Re: Botley West Solar Farm (“BWSF”) DCO Application– EN010147

**Response to Consultation dated 04/09/2026 on the Applicant’s July 2026
material**

**Representation by Hanborough Parish Council –
Interested Party No. [REDACTED]**

Figure 1 - Reduction in Overall Development Area Animation

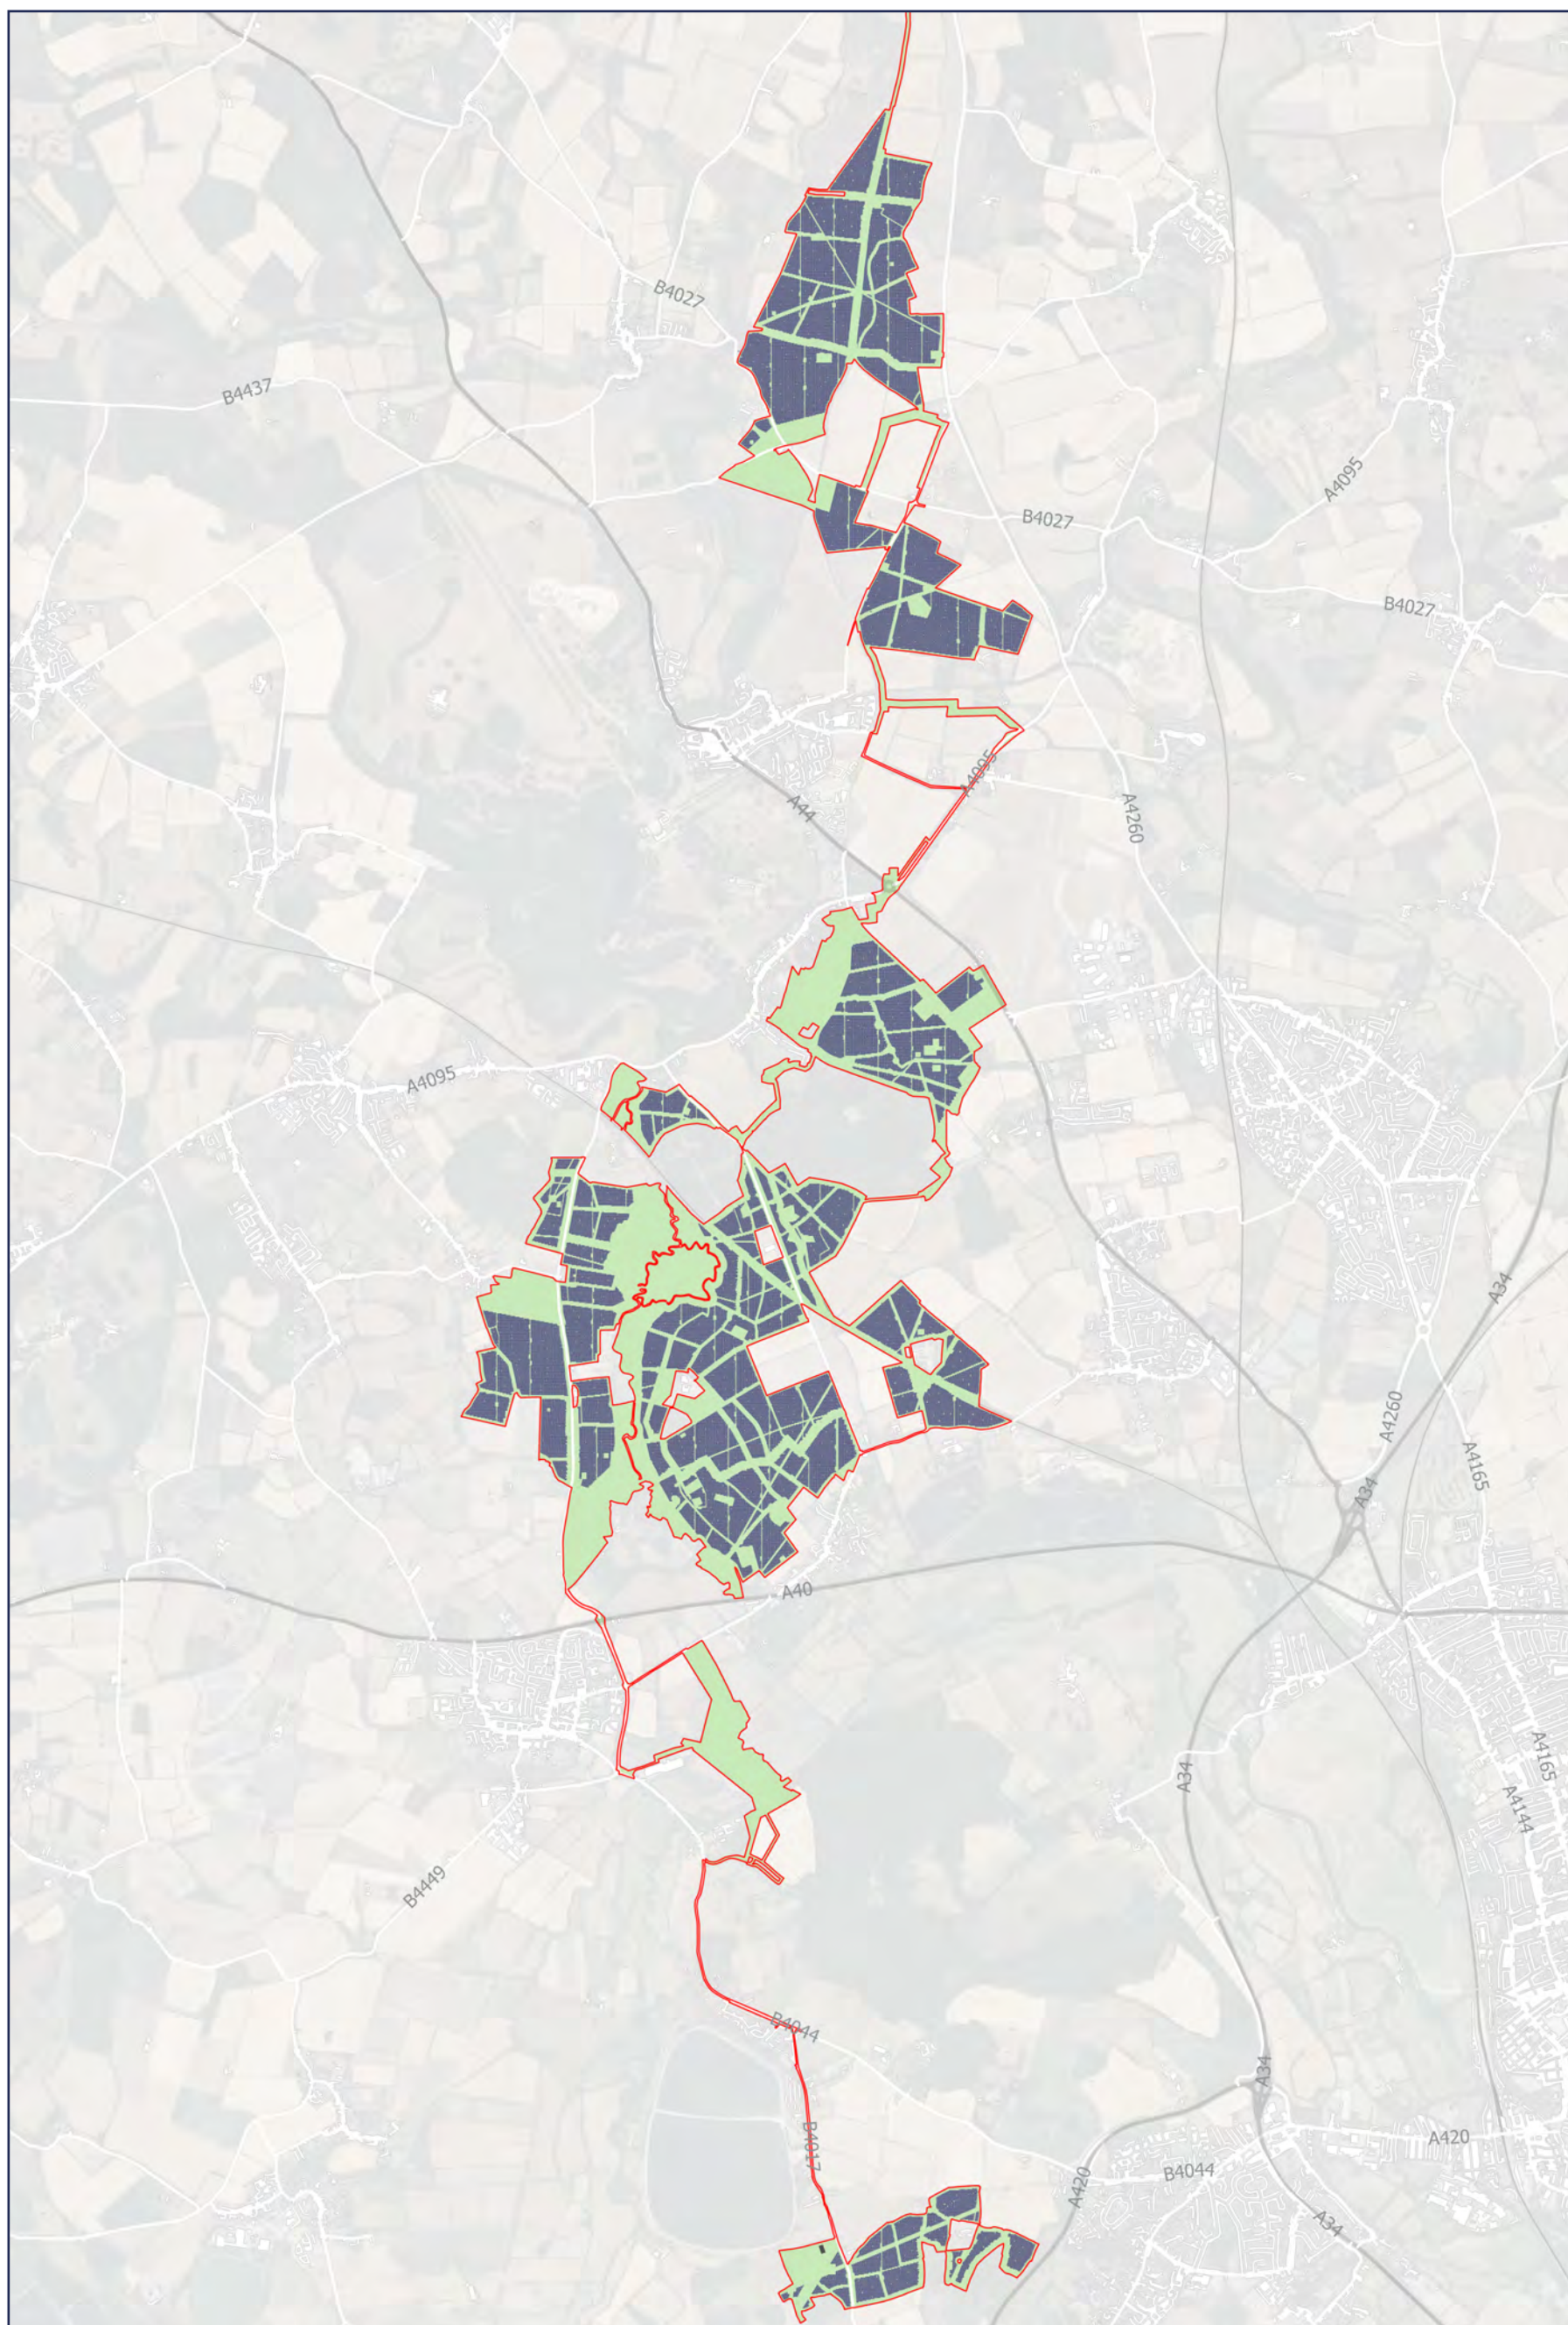
10. HPC draws attention to one particular issue as a strong illustration of this concern. The Revised Masterplan referred to above in paragraph 5 now discloses, at page 4 a significant reduction in both the land area proposed to be used for the installation of solar PV panels, down by some 120.2 hectares (321 acres), and a purported reduction in the generated output of electrical energy down from the original much cited 840MWp to a lower figure of 620MWp. Those are significant figures in their own right, but also must have an effect on the design and layout of the BWSF project.

11. HPC is greatly concerned that this reduction in installation size and generation capacity does not seem to have any impact on the overall red-line boundary of the Application. We do not understand why this is so: we do not see why the overall size of the BWSF project remains the same, so that it would remain subject to the general control of the Applicant / Developer rather than being allowed to remain as it currently is - land in general agricultural use, growing a range of crops (more than adequately) and forming part of the significant overall landscape in this part of Oxfordshire.

12. In our view, there is no justification for on the one hand reducing the land area purportedly needed for the BWSF scheme, and on the other hand retaining control of that land but not for renewable electricity generation.

If land is genuinely unnecessary for the development, there is no obvious justification for retaining it within the red-line boundary. It should be removed so that the extent of the authorised development is clear and cannot subsequently be expanded within a broad consented area.

Figure 5 - Illustrative Masterplan

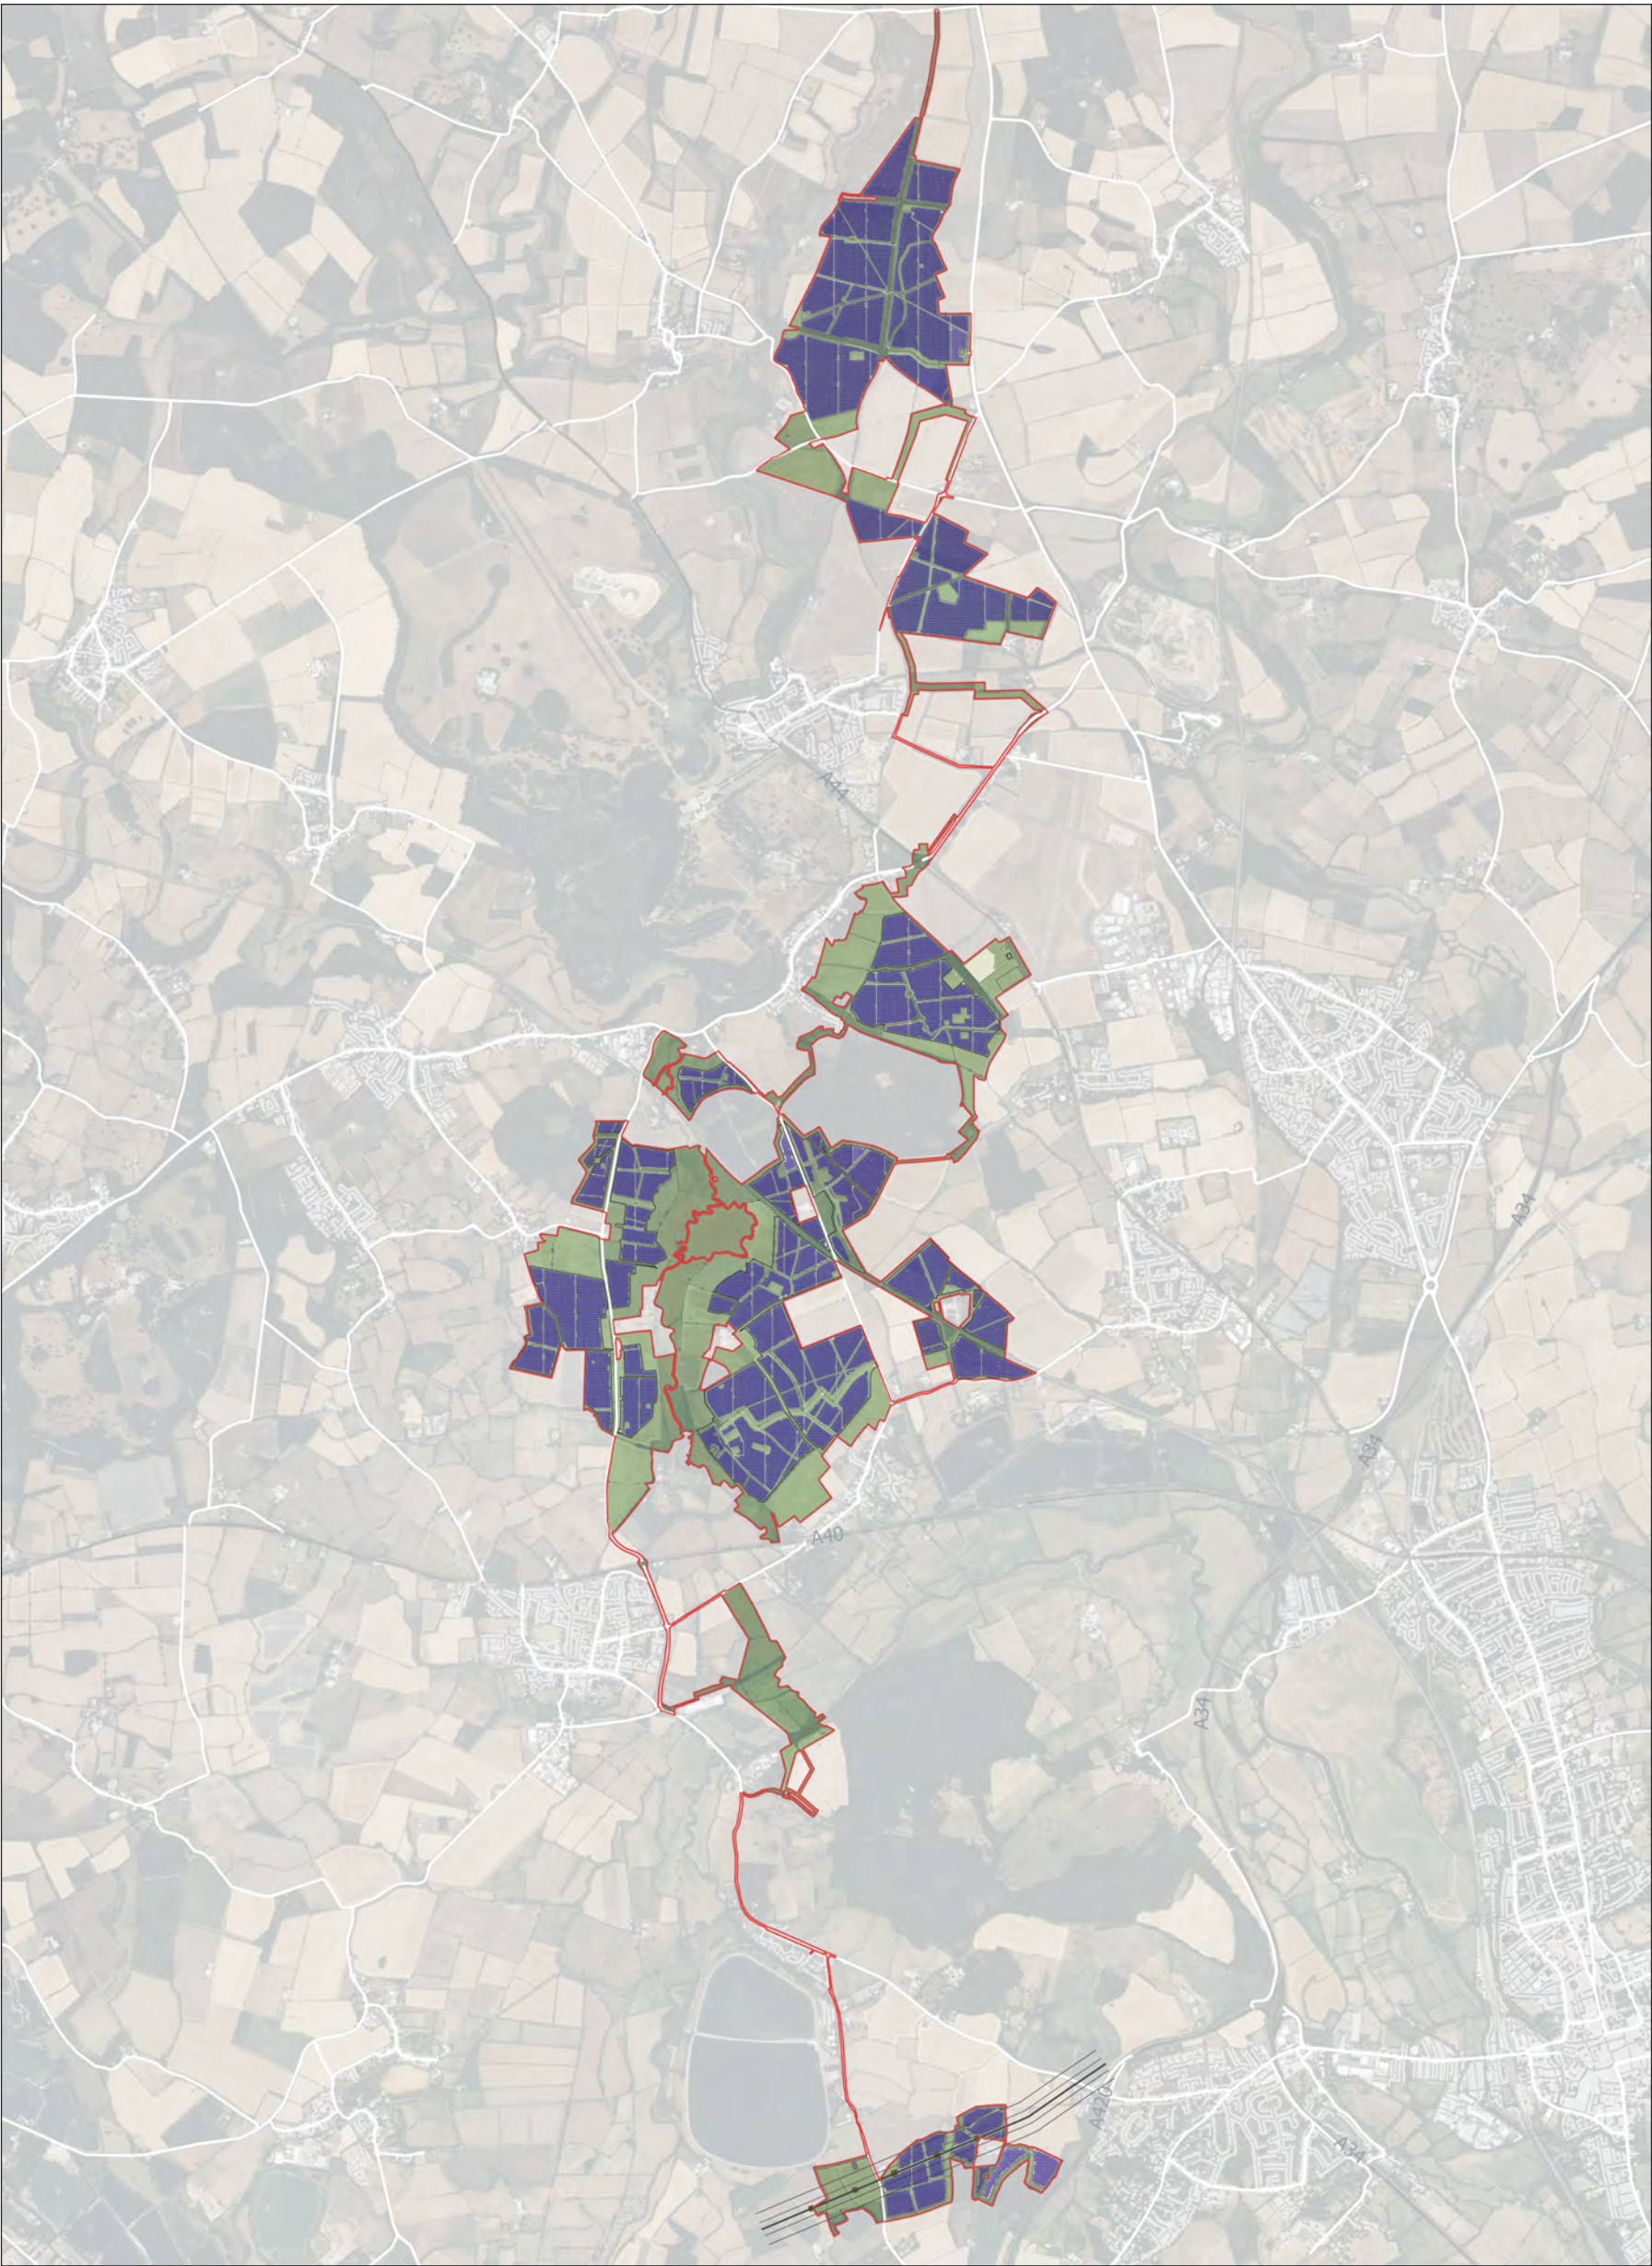
14. The latest outline Residential Visual Amenity Plan (oRAP) and Masterplan Revision 5 are particularly concerning. The latest Masterplan appears to establish a 100-metre default separation between residential properties and solar infrastructure, compared with the 250-metre default position presented in Masterplan Revision 4 following the Examiners' consideration. The basis for this substantial reduction has not been adequately demonstrated.

15. More importantly, the latest approach appears to defer important decisions about the final relationship between individual homes and the solar development until after consent has been granted. For residents of Hanborough Parish, these are not minor matters of detailed design. The distance between their homes and a large industrial solar installation can materially affect visual amenity, outlook and the experience of living beside the development.
